AB/10/26/S73

Address: Howth House 33 Tarrant Street Arundel BN18 9DG

Proposal: Variation of condition 2 imposed under AB/79/25/HH in relation to approved plans.

Drawing Name  
Site Plan and Outbuilding -  
Proposed

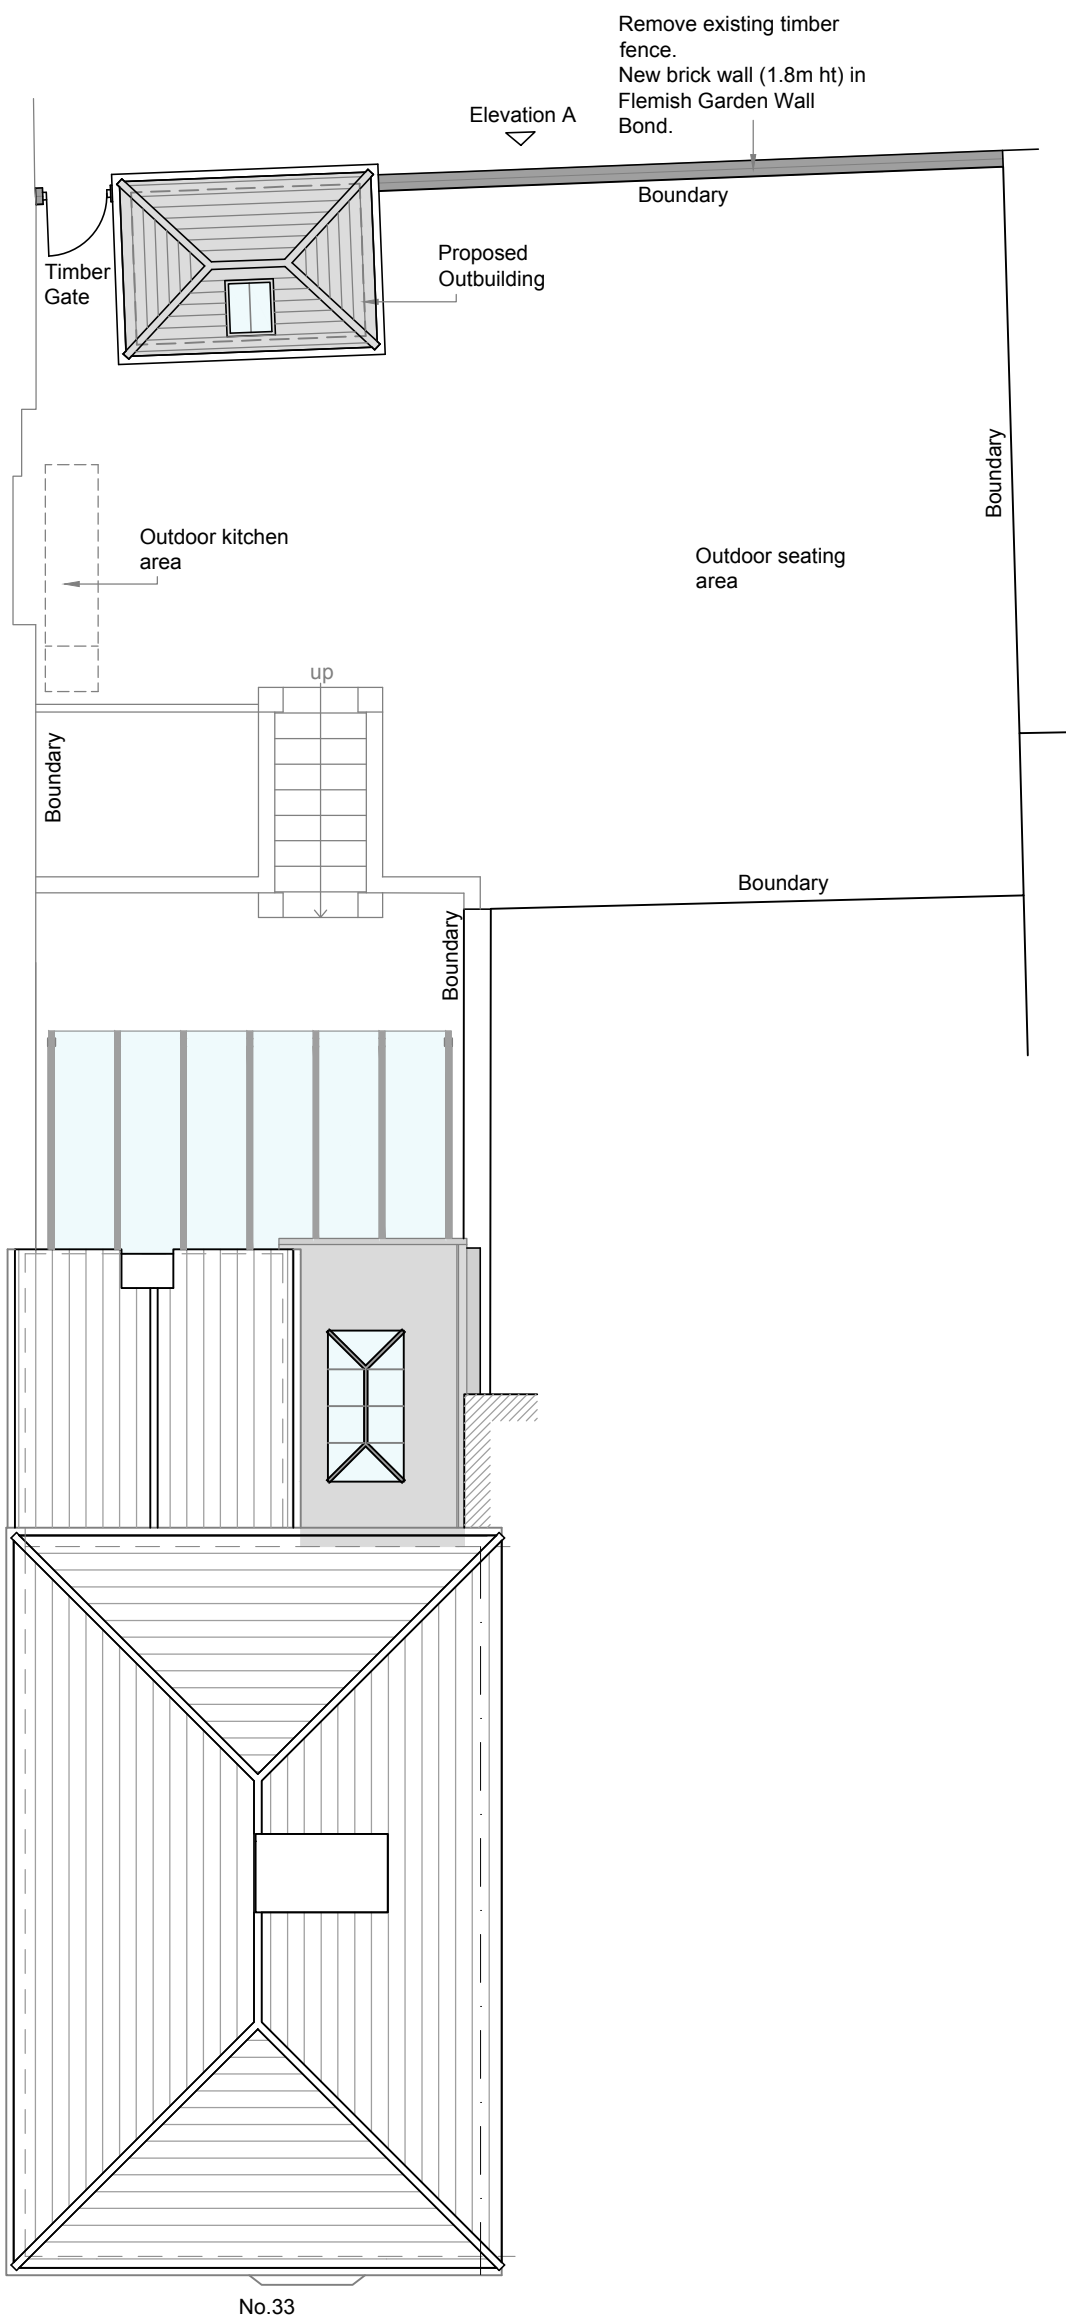
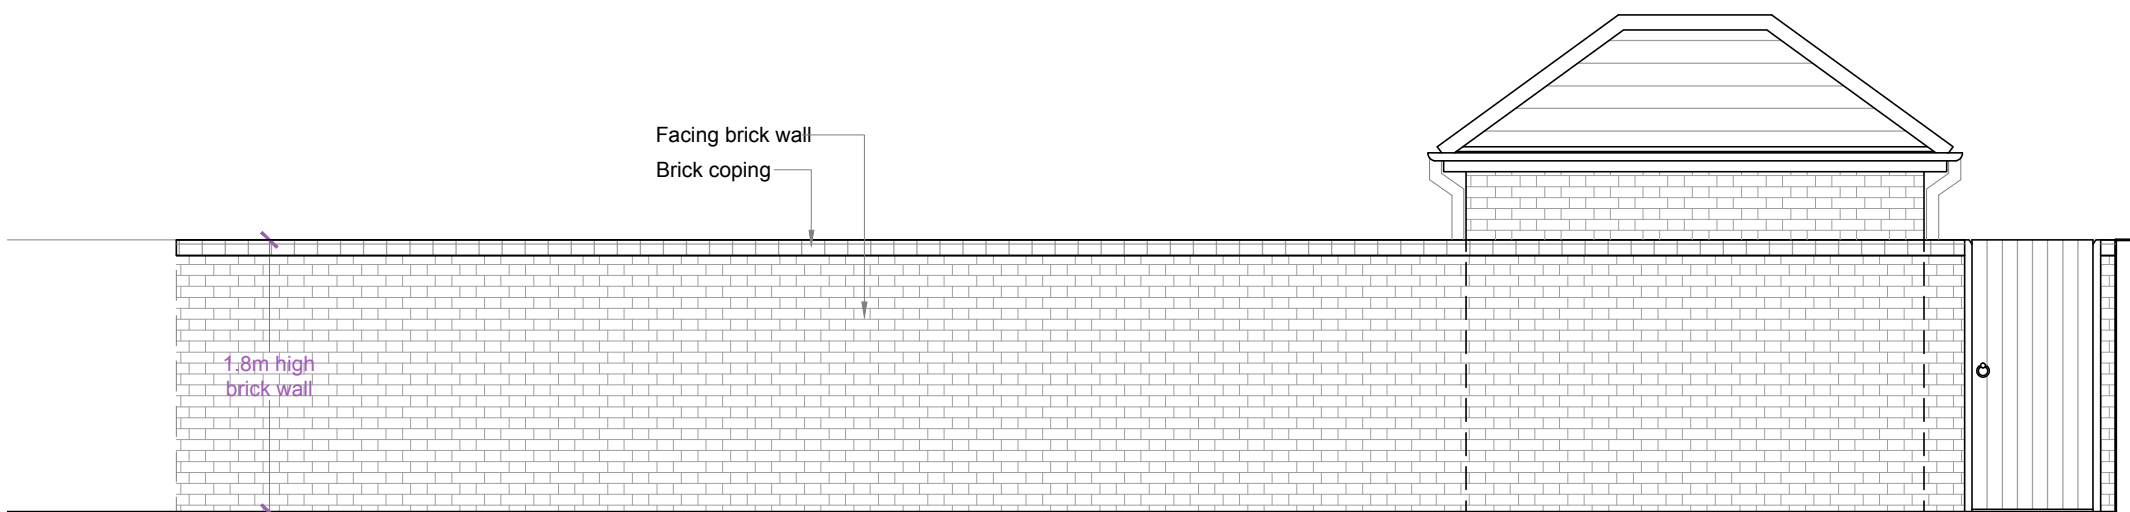
I note that the amendment relates to the proposed outbuilding. The position of the outbuilding has changed along with its proposed dimensions. I also note that the location of the proposed garden gate has also moved. Overall, I think that the amendments are acceptable.

You may wish to reapply the any conditions regarding materials, the new gate and colours. You may also find it helpful to confirm details of the rooflight.
